SF-21-023

PROJECT INFORMATION		
CLOVERLEAF	5/13/2021	
Project Name	Date	PCD File No.

Pond P1 Spillway

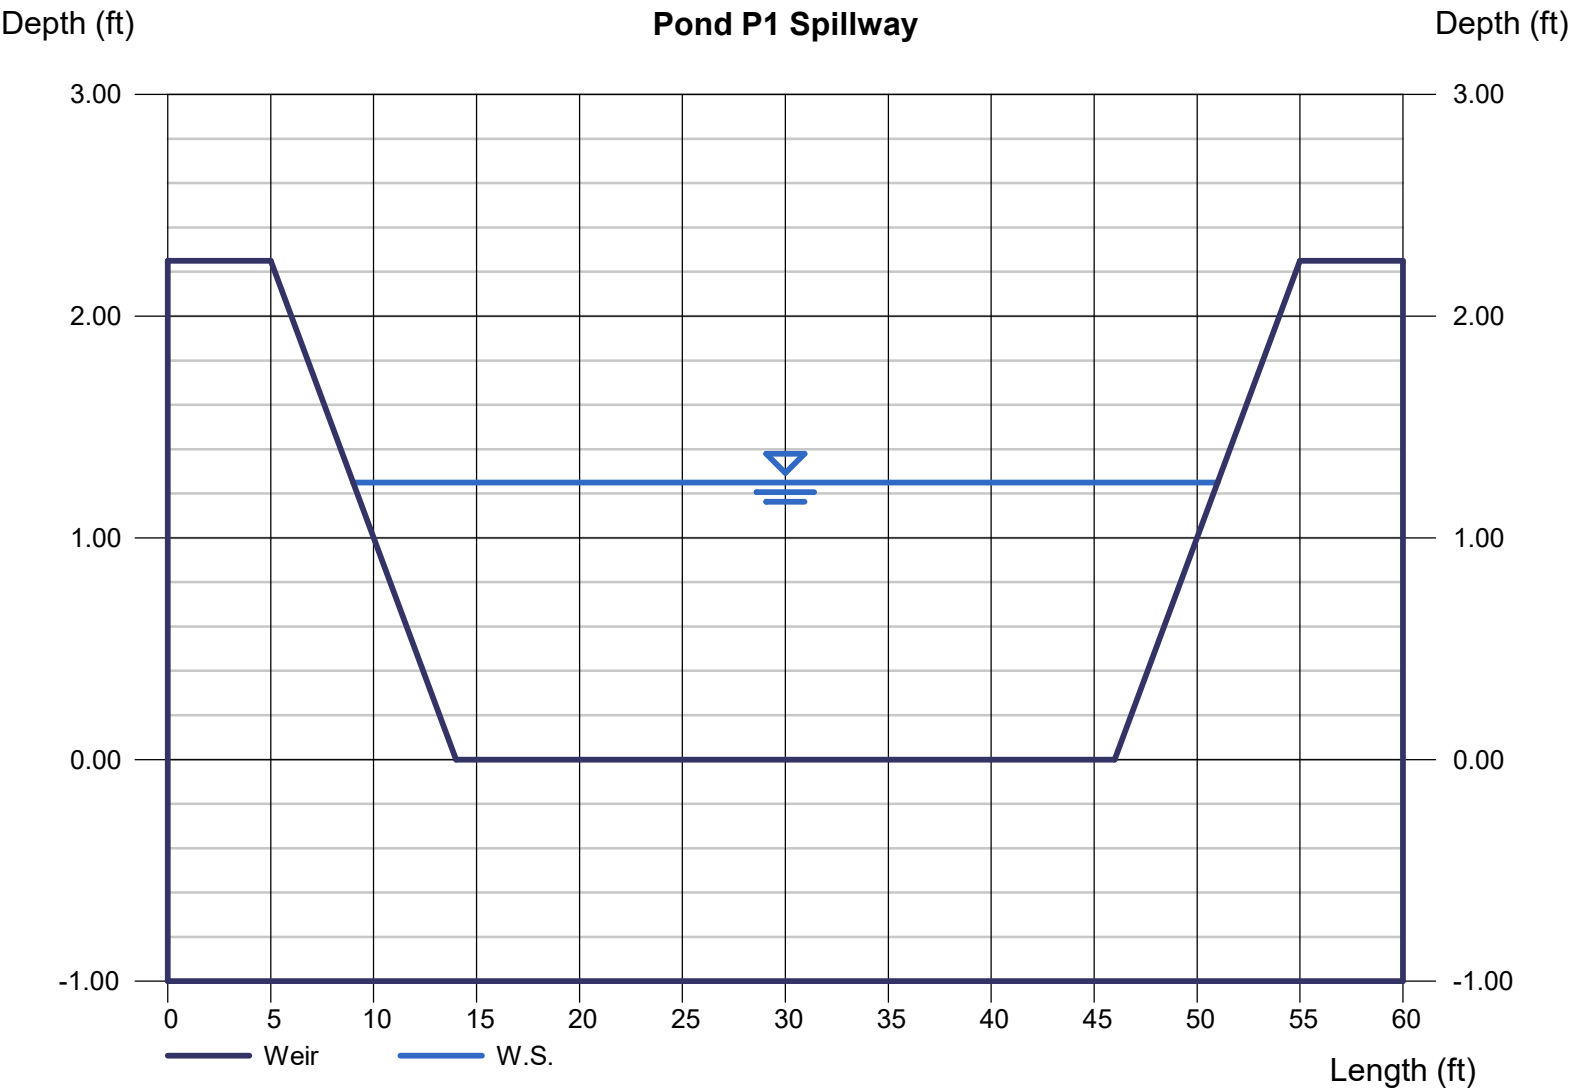
revise spillway to 4

RESPONSE: REVISED.
